**RE: COUNCIL SUBMISSION REGARDING EXHIBITION OF STATE SIGNIFICANT
DEVELOPMENT SSD 9483
CHATSWOOD EDUCATION PRECINCT (UPGRADES TO CHATSWOOD PUBLIC
SCHOOL AND CHATSWOOD HIGH SCHOOL)**

I write to you regarding the exhibition of the development application for the Chatswood Education Precinct involving upgrades to Chatswood Public School and Chatswood High School at 5 Centennial Avenue and 24 Centennial Avenue, Chatswood (State Significant Development SSD 9483).

1 Elevation East P1
SCALE: 1 : 250

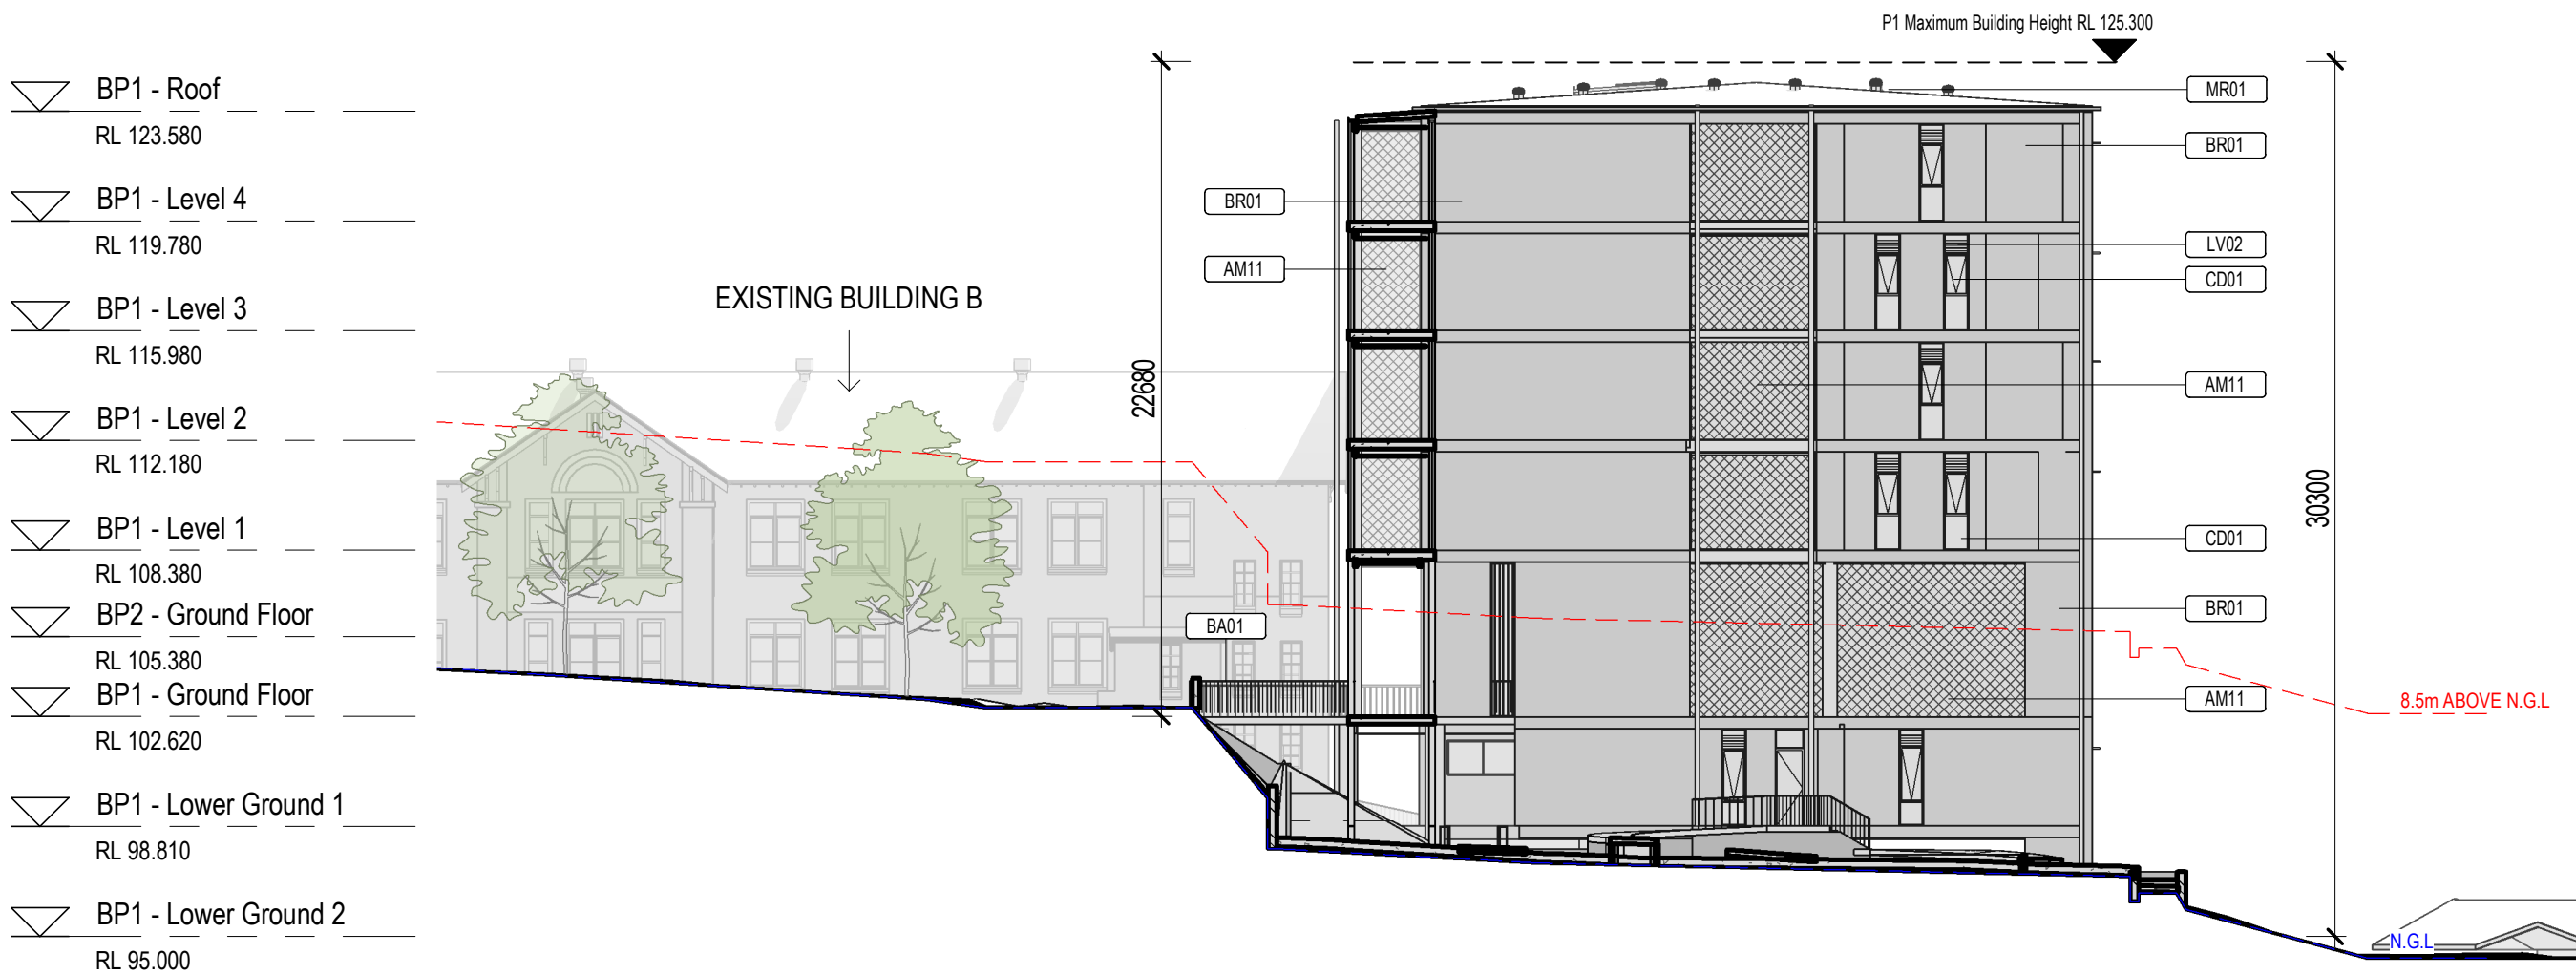
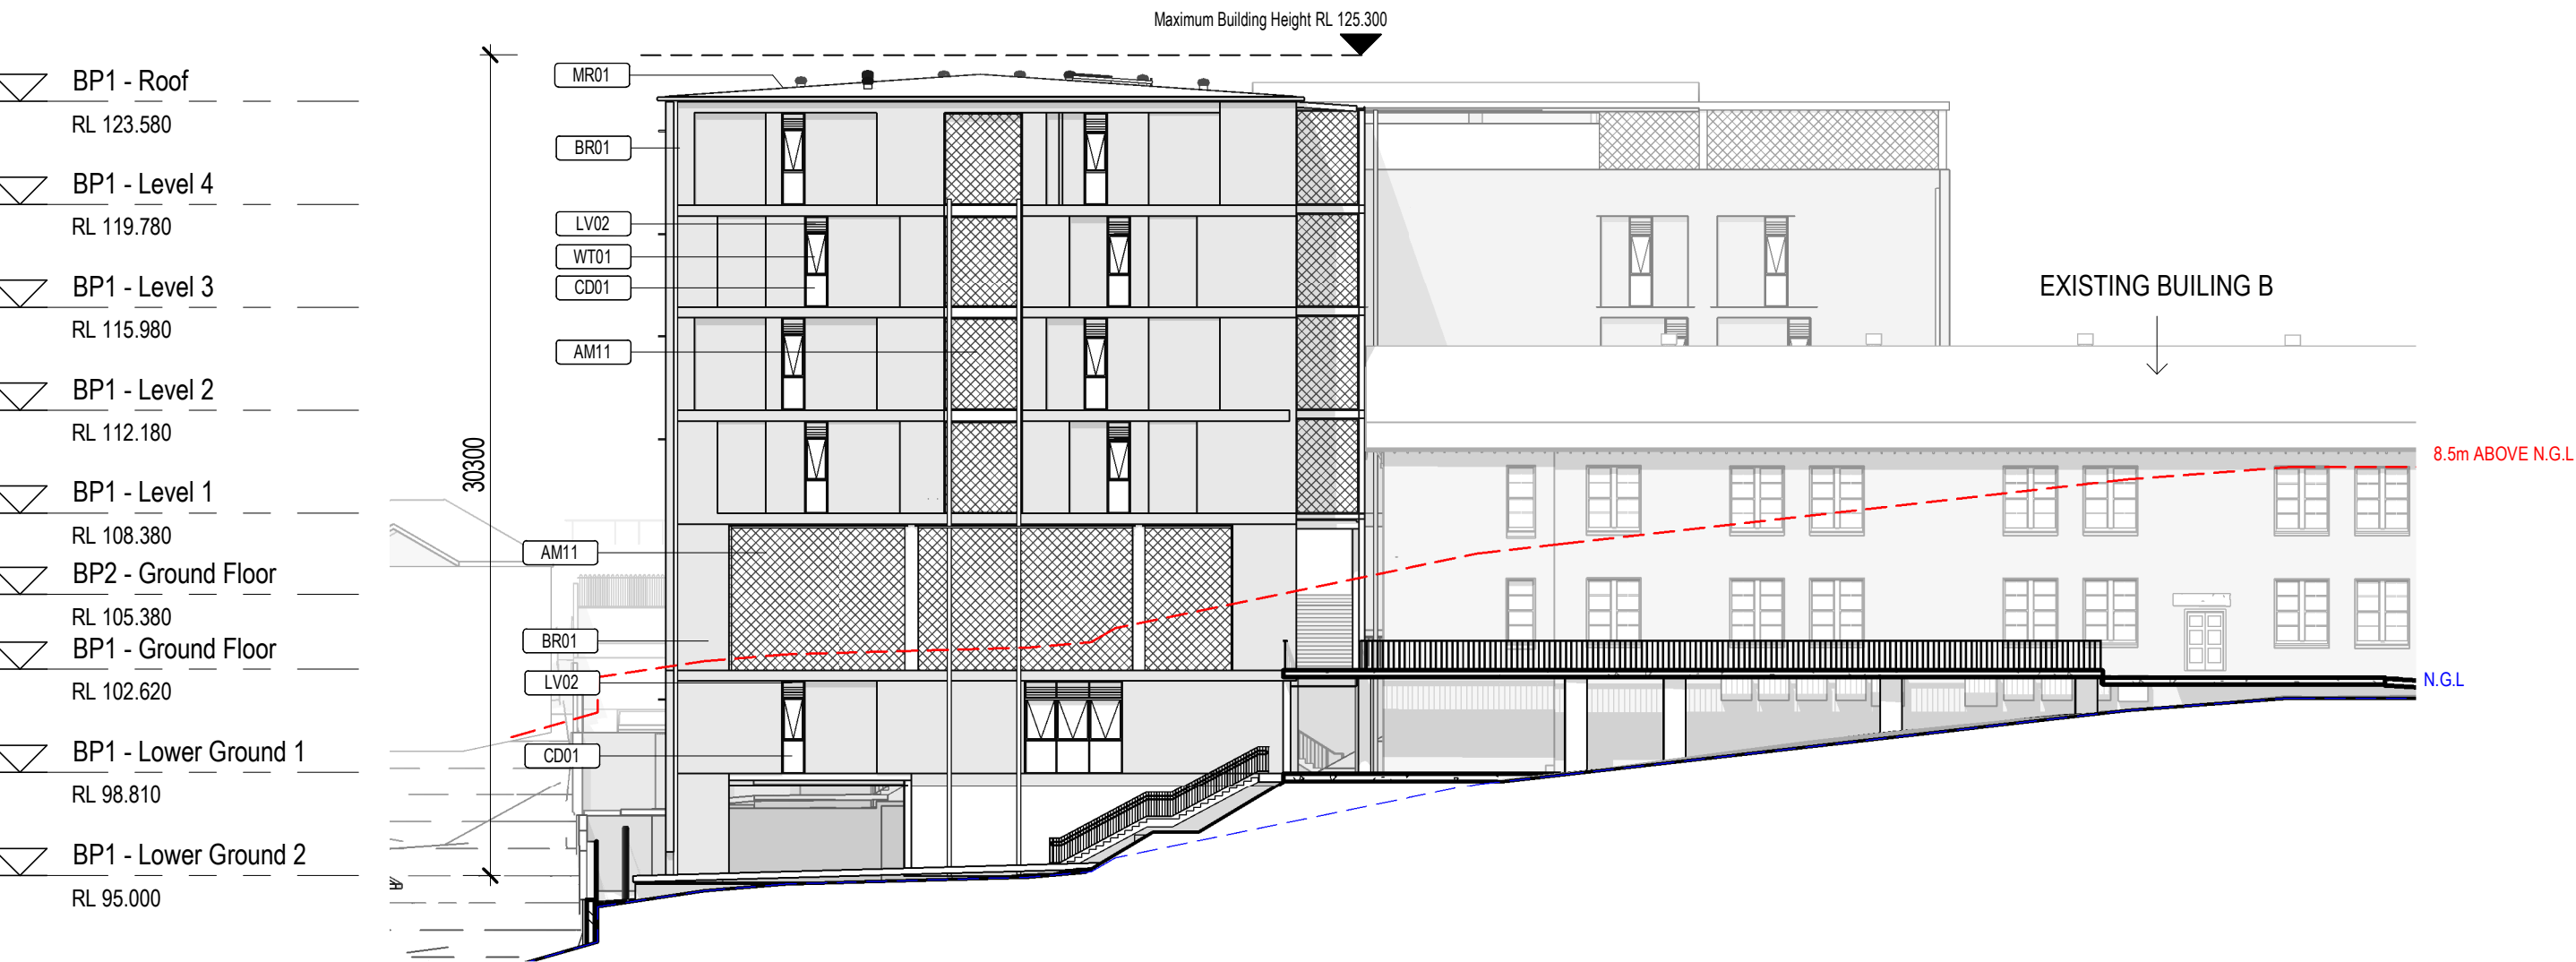
Open playing areas and windows on these buildings should be located and designed to minimise noise and overlooking to the neighbouring low density residential properties. In addition proposed building P1, being the closest building to a boundary, should be designed carefully to minimise visual bulk to the north and west boundaries.
